# LAND OFF WEST MOOR CROFT ROAD, GOLDTHORPE (PHASE 3)

**Further Supplementary Ecological Information (SEI) including  
Revised Biodiversity Net Gain (BNG) assessment of land  
within New Park Springs**

SLR Ref: 424.03044.00237  
Version No: 1  
August 2022

An SEI report was produced by SLR Consulting in June 2022<sup>1</sup>, and this was subsequently reviewed and commented on by Ms Katie Lawrence, Planning Ecologist with Barnsley Council, in an email dated 30<sup>th</sup> June 2022.

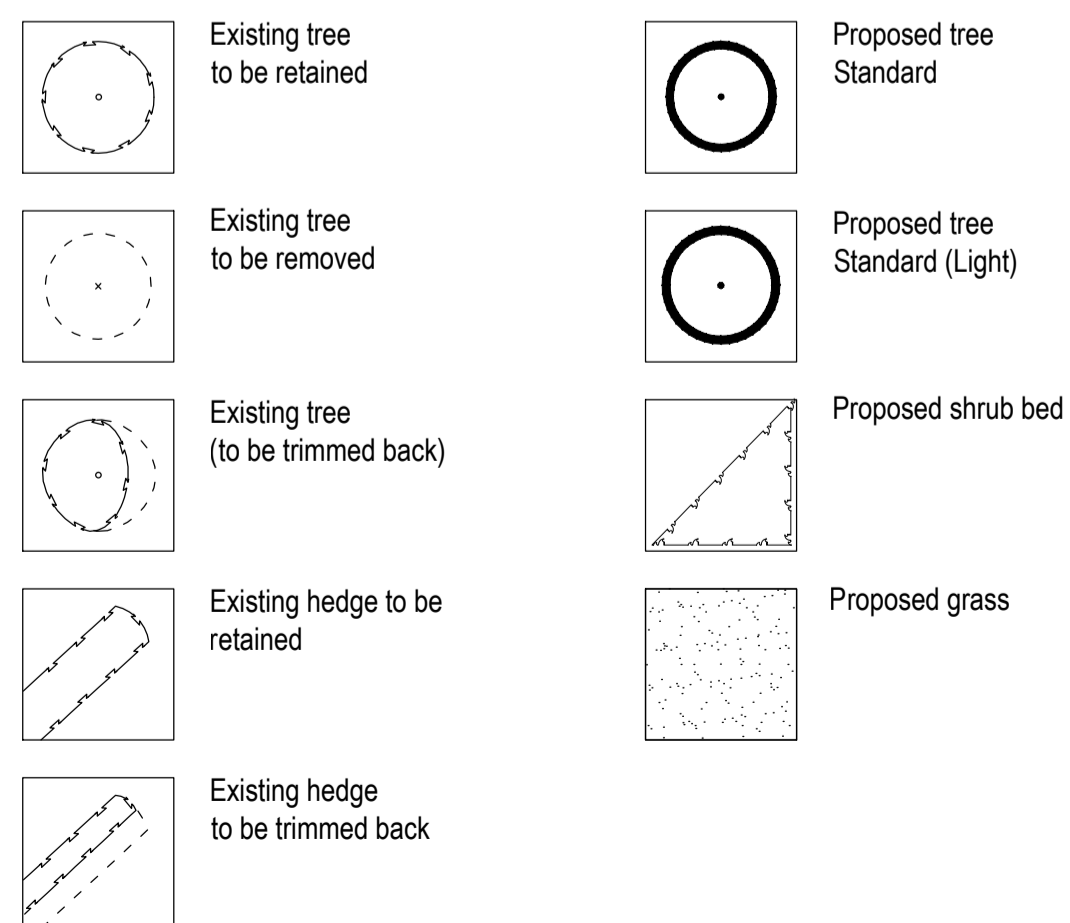
- *The landscape proposals show retained hedgerows on site. The metric details that all lengths of hedgerow will be retained on site; however Detailed Landscape Proposal (2 of 2) drawing no. 3627/3 appears to show a section of hedgerow to the north-western corner of the site to be removed. This should be confirmed and if proposed for removal, the metric should be amended accordingly.*
